Ribble Valley Borough Council
Church Walk,
Clitheroe,
BB7 2RA

Phone: 0300 123 6780
Email: lhscustomerservice@lancashire.gov.uk
Your ref:
Our ref: LHS/CS/3/2015/0950
Date: 16th December 2015

Proposal:	25 Chatburn Park Drive Clitheroe
Location:	Two storey side extension and rear single storey extension with enlarged front driveway.
Grid Ref:	375063 - 442490

GROUND FLOOR AND SITE PLAN

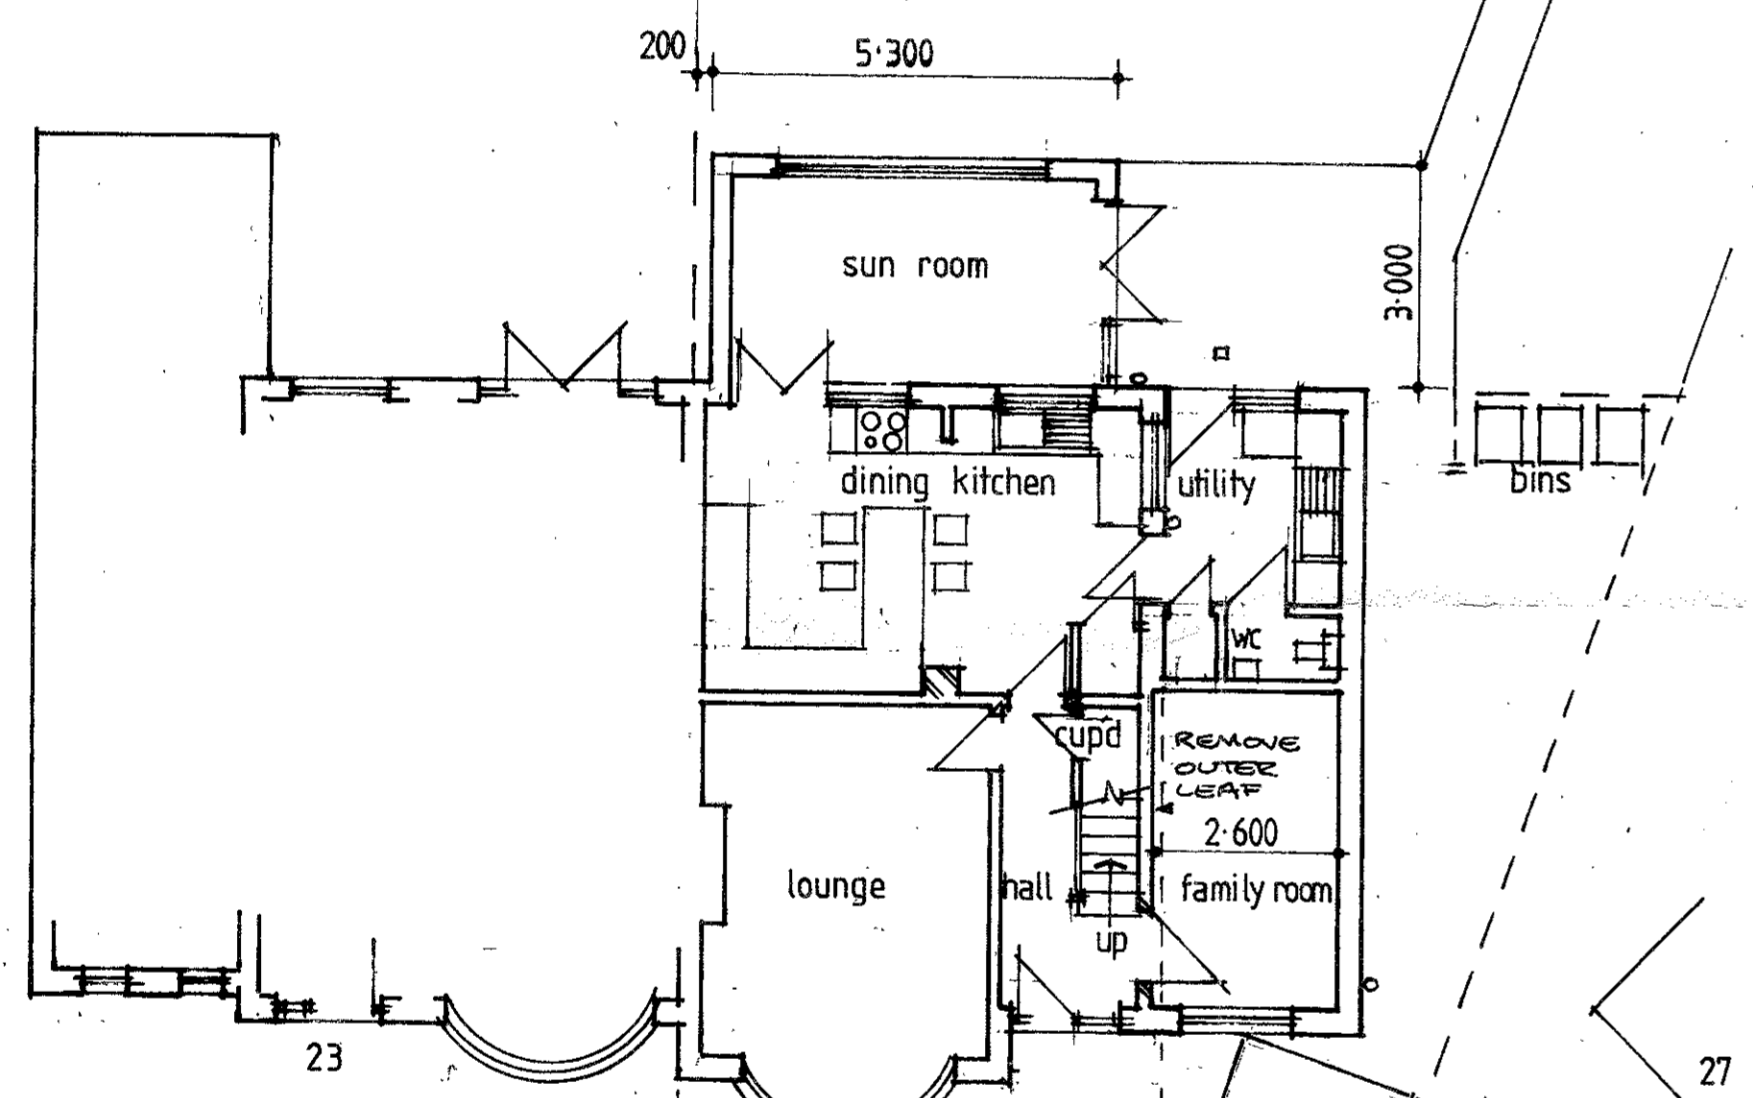
The Highway Development Control Section does not have any objections in principle to the proposed extension, providing the applicant can provide three off road car parking spaces, in the interest of amenity for neighbouring properties.

Based on the Joint Lancashire Structure Plan the Highway Development Control Section is of the opinion that the applicant should provide three off road car parking spaces for 4 bed room properties.

Due to the location of the property the third car would need to front a neighbouring property and potentially obstruct the neighbouring drives. Additional issues for refuse vehicles and delivery vehicles passing parked cars at this location.

The widened vehicular access, within the adopted highway fronting the property will need to be constructed under a section 184 agreement of the 1980 Highways Act (Vehicle crossings over footways and verges); The Highway Authority hereby reserves the right to provide the highway works within the highway associated with this proposal. Provision of the highway works includes design, procurement of the work by contract and supervision of the works. The applicant is advised to contact the Environment Directorate before works begin on site. Further information and advice can be found at www.lancashire.gov.uk and search for vehicular crossings.
